DELEGATED DECISION TO DETERMINE PLANNING APPLICATIONS

Reference No:	2023/62/91053/E
Site Address:	16, Riley Lane, Kirkburton, Huddersfield, HD8 0RZ
Description:	Erection of single storey lean to rear extension
Recommending Officer:	Elenya Jackson

OFFICER REPORT

JOB NO	DRG NO	REV	SCALE @ A2	DATE
WHPG 23/0026	02	A	AS	30 03 23

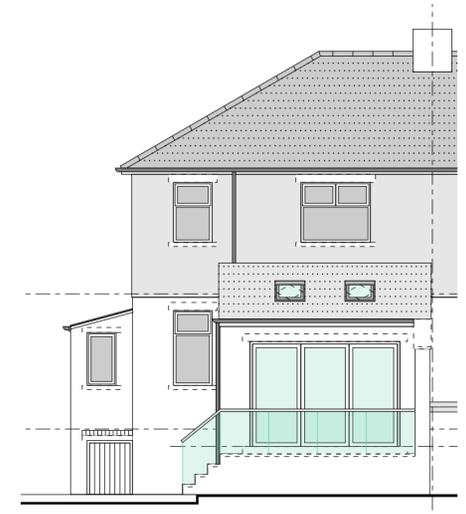
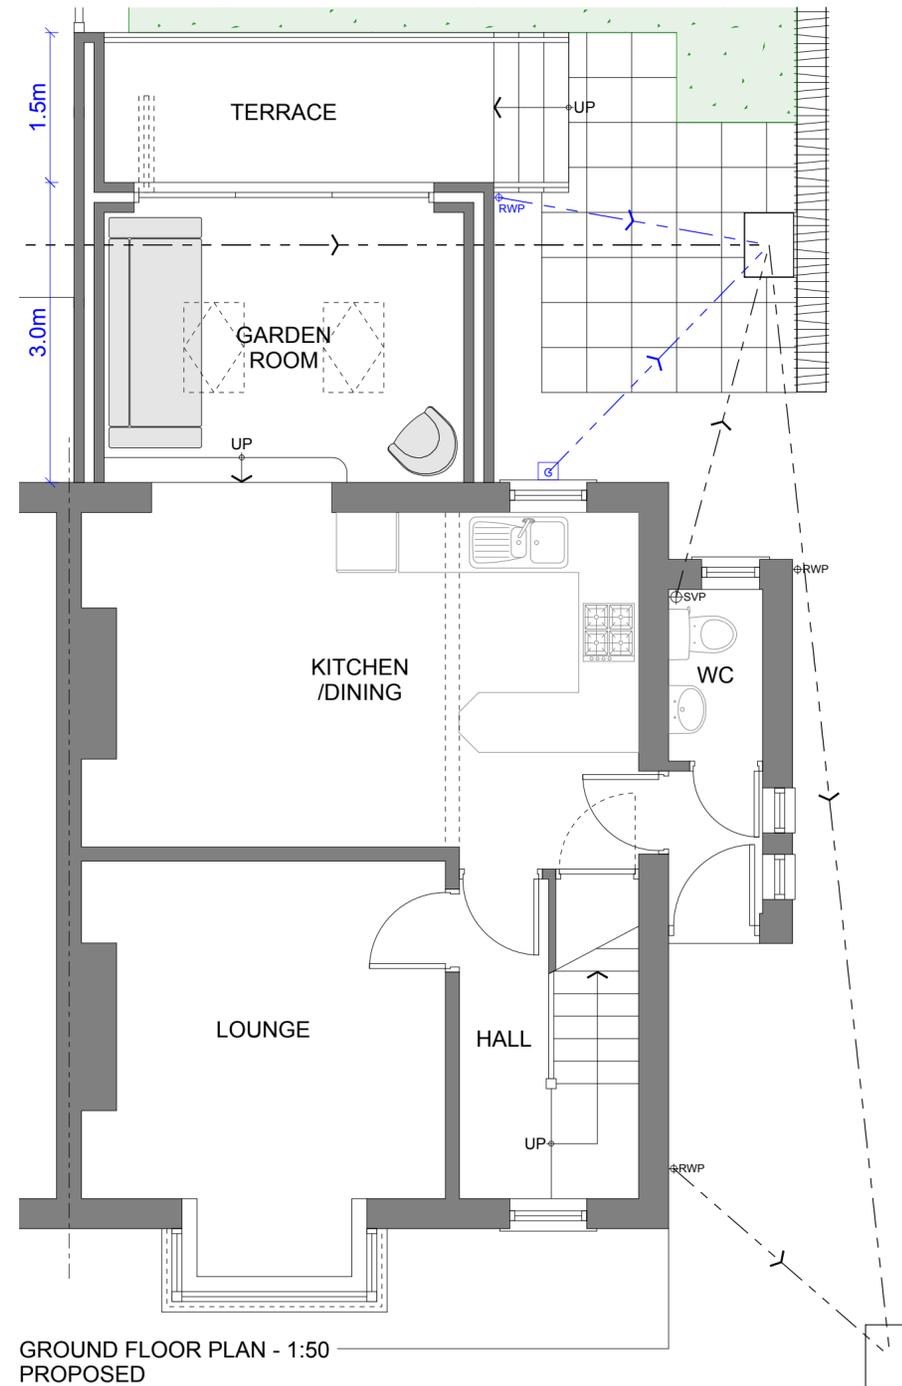
Overlooking: The proposal has been amended since submission to remove an element of decking the rear. This has been replaced with steps exiting the property. It is considered that rear facing windows are a usual relationship between dwellings and the introduction of stairs would be a continuation of the existing relationship between the dwellings. No significant issues regarding overlooking.

Overshadowing/loss of light/overbearing: The proposal has been reduced in depth since its initial submission and would extend 3m beyond the rear elevation of the dwelling. There is currently a small storage structure on the boundary of no.18 and it is considered that this separates the dwelling from the rear amenity space of no.14. The proposed structure would feature a maximum height taller than a usual single storey extension as the property is raised from the garden level; this is reflected in the layout of no.18. It is considered that due to the proposal extending 3m beyond the rear elevation of the existing dwelling and being single storey in scale when compared to the floor level of no.18, no significant issues would arise regarding overshadowing/loss of light or overbearing.

Officers requested that the proposed decking originally submitted with the application was removed to reduce the scale of the proposal immediately next to the shared boundary between the dwellings.

The proposal has been amended since submission to remove decking to the rear of the proposal to alleviate concerns regarding overshadowing and overbearing.
